Application No: FG/46/20/PL

Site Address: The Tudor Close Public House Ferringham Lane Ferring BN12 5NQ

Description of works: Conversion of the existing Public House (Class A4) to create 7 No residential units comprising 5 No 1-bedroom units & 2 No 2-bedroom units & the erection of 2 No 2-bedroom semi-detached chalet bungalows with associated car parking & landscaping. This application may affect a Public Right of Way.

Thank you for your internet representation made on 10th May 2020 which has been recorded as an objection with the comments as follows:

Drawing Title:
Landscape Plan
Block Plan
As Proposed

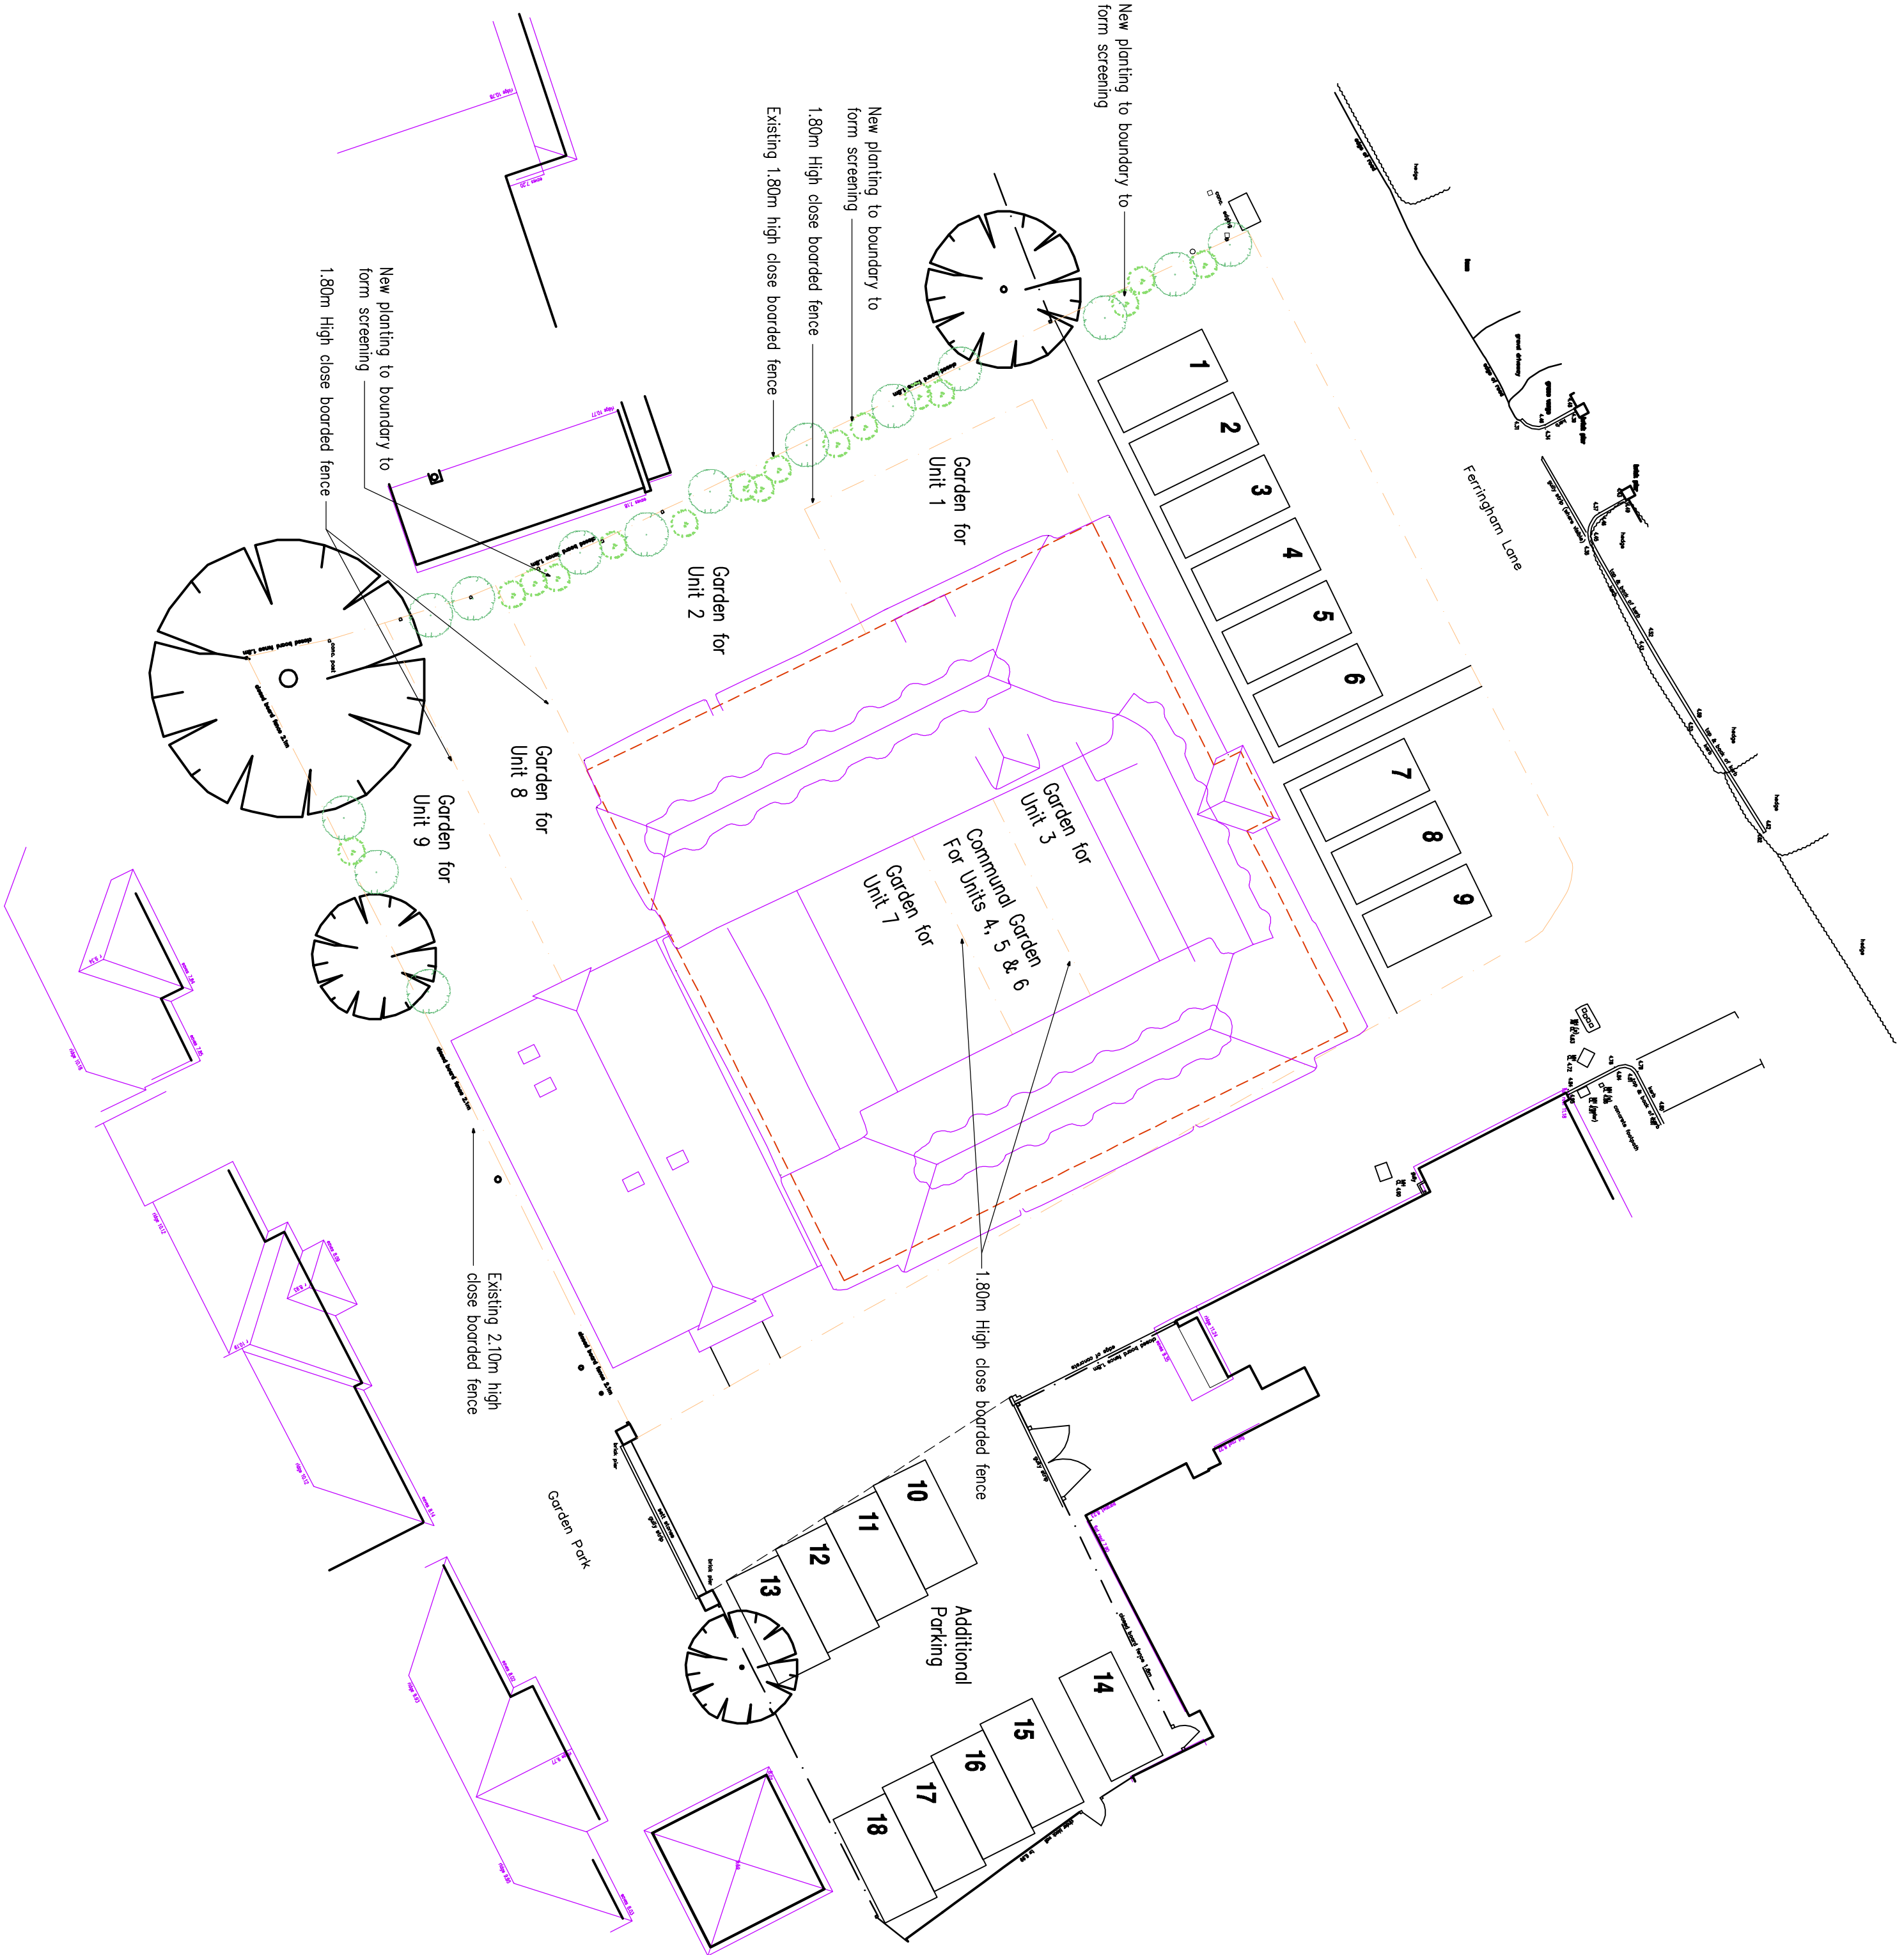
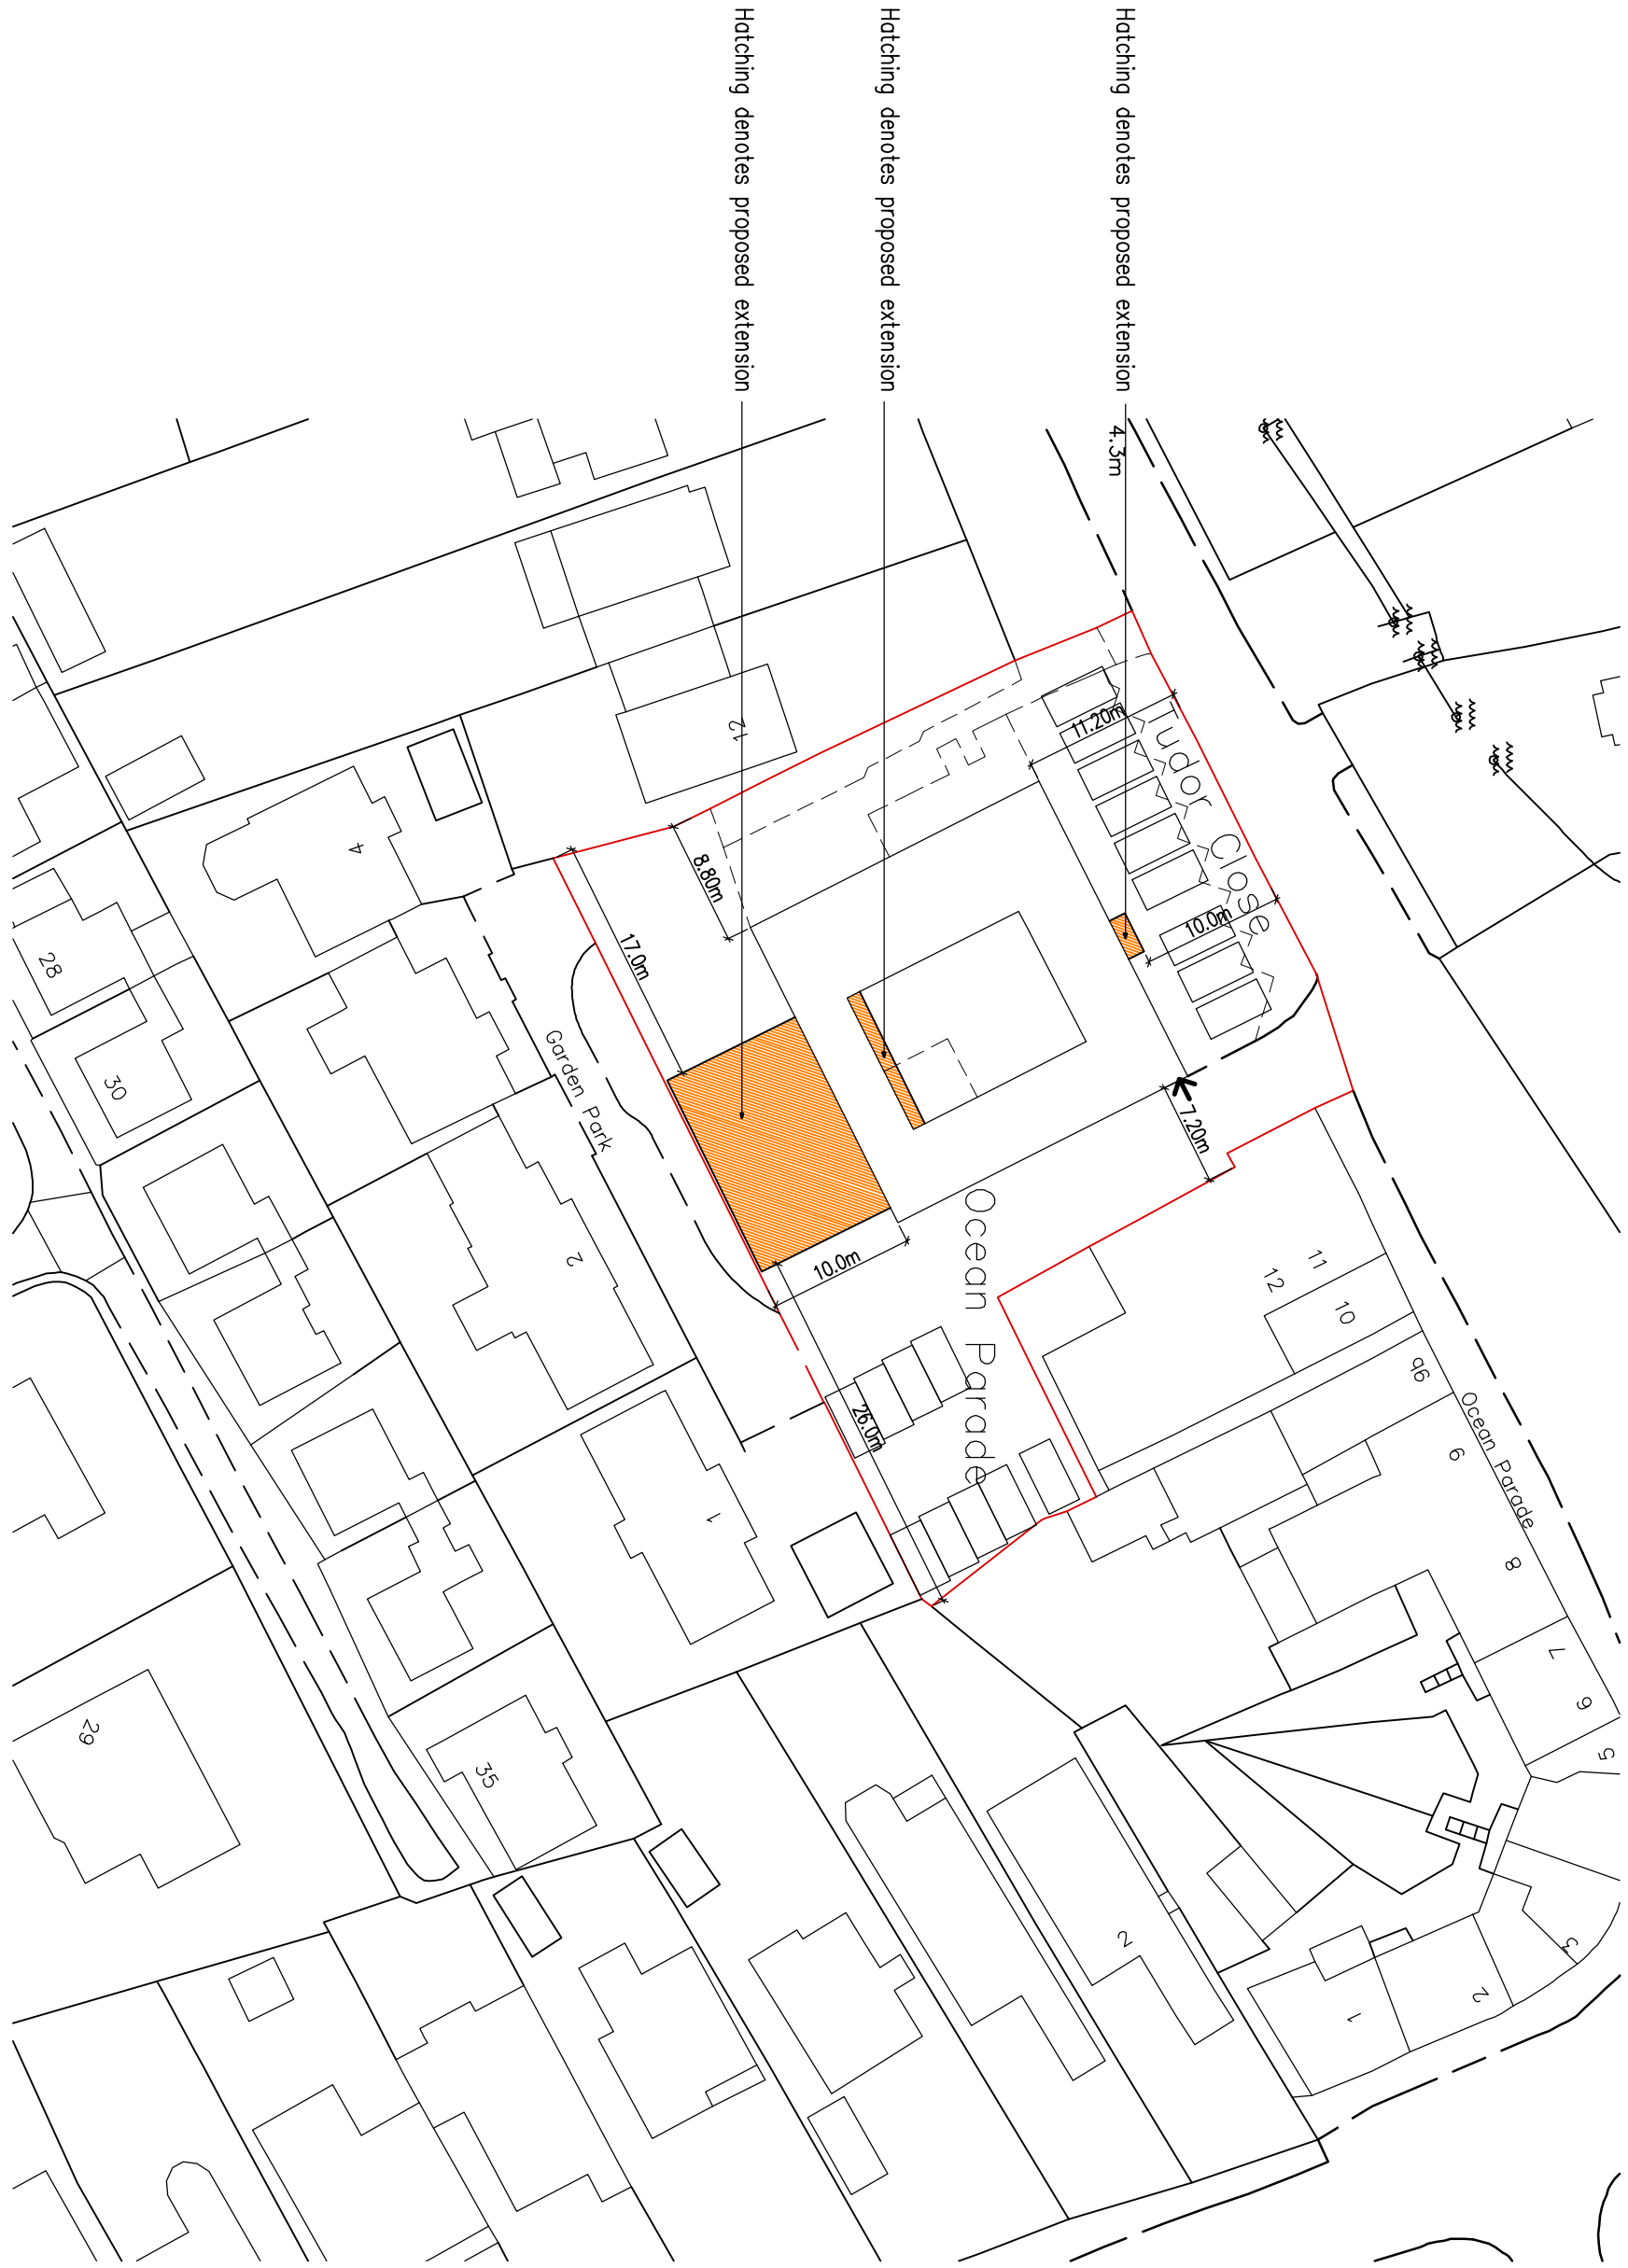
I support the conversion of the existing building into flats, but not the addition of the 2 semi-detached bungalows to the rear. They would mar the appearance of the original building, and be over-intrusive and far too close to the bungalows behind the site.
